Re: Application No SSD 5589_2012, Glebe Island Expo, Sommerville Road, Glebe Island

I am a resident directly affected by the above proposal as I live in an apartment building opposite Glebe Island with living area, balcony and bedroom looking out across Johnstons Bay towards the proposed Island Expo. I understand the need for alternative temporary sites to host major exhibitions during construction at Darling Harbour but would like to voice my objections/concerns to the proposed Plans:

- 1 SICEEP MAIN ENTRANCE
- 2 VEHICLE DROP-OFF ZONE
- 3 SICEEP RECEPTION (BELOW)
- 4 SICEEP ADMINISTRATION OFFICES
- 5 PRE-FUNCTION AREA
- 6 5000m² EXHIBITION HALL

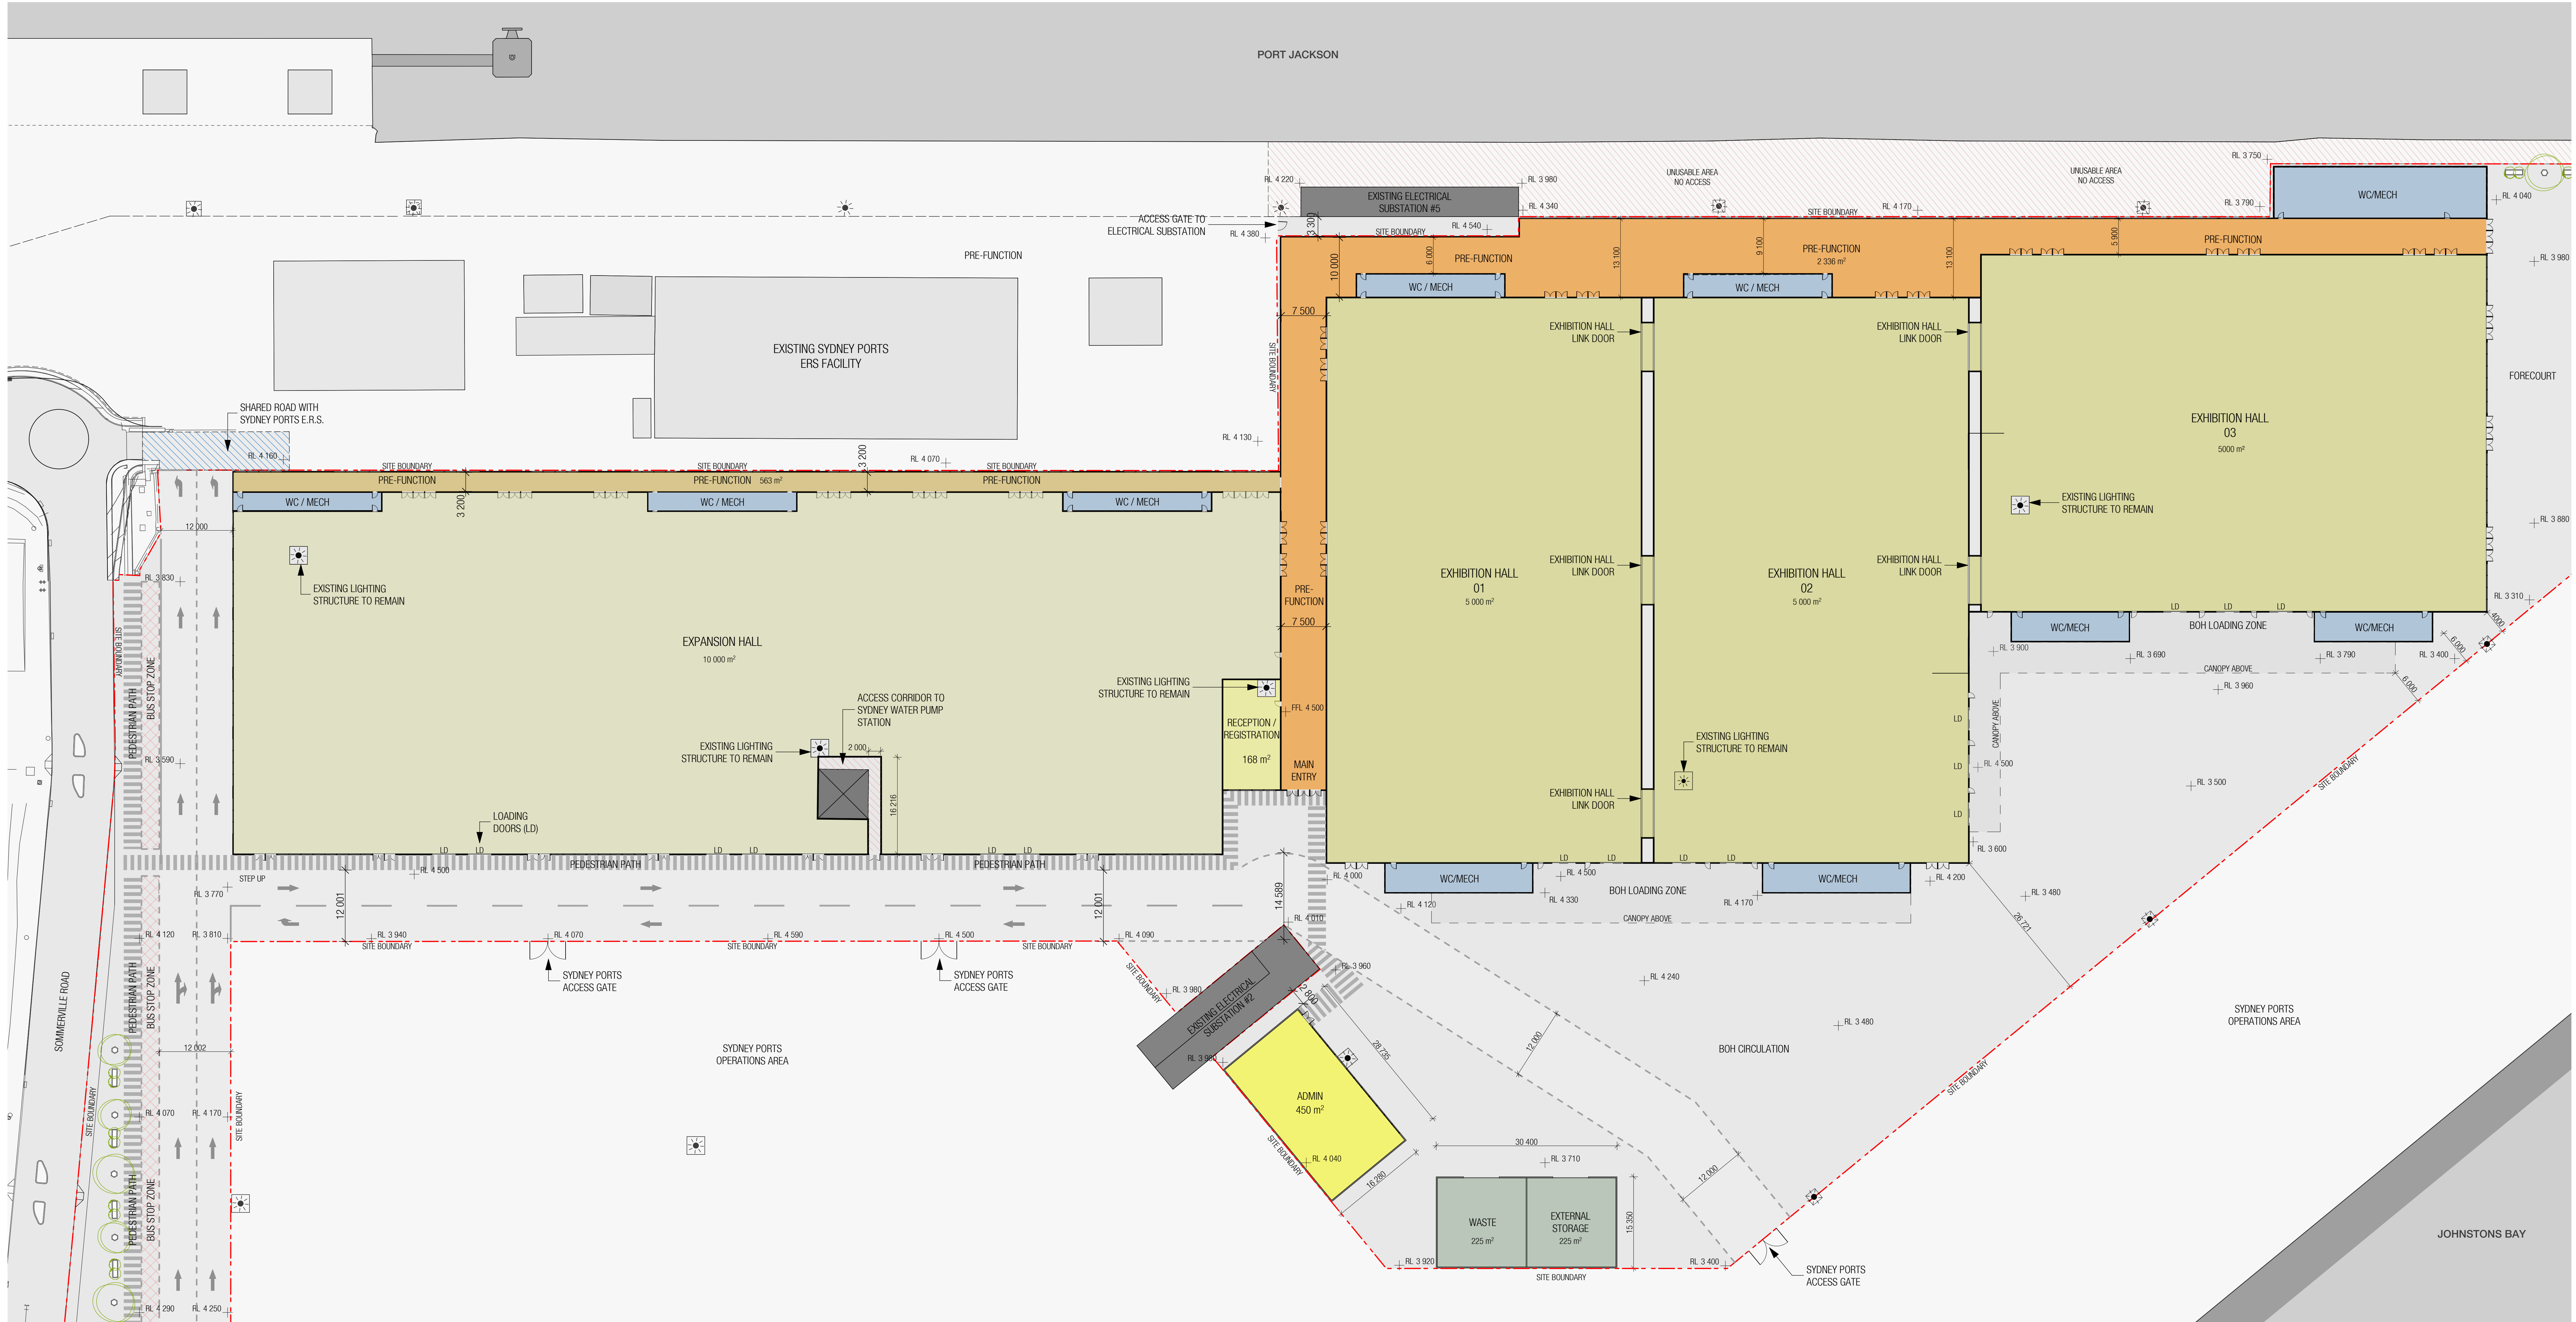
It came as a shock to find that I am expected to look out from the front of my apartment to the rear of the Island Expo, which I understand accommodates the toilet and garbage facilities and all the maintenance services these facilities will require, for at least the next 3 years. There are forty four apartments in this building facing in this direction and a number of other apartment buildings in Jacksons Landing face in the same direction across Johnstons Bay. I do **object** to this. I would like to know if it is planned to put any type of screening in place? Also whether there will be time restrictions on garbage collection trucks visiting the site?
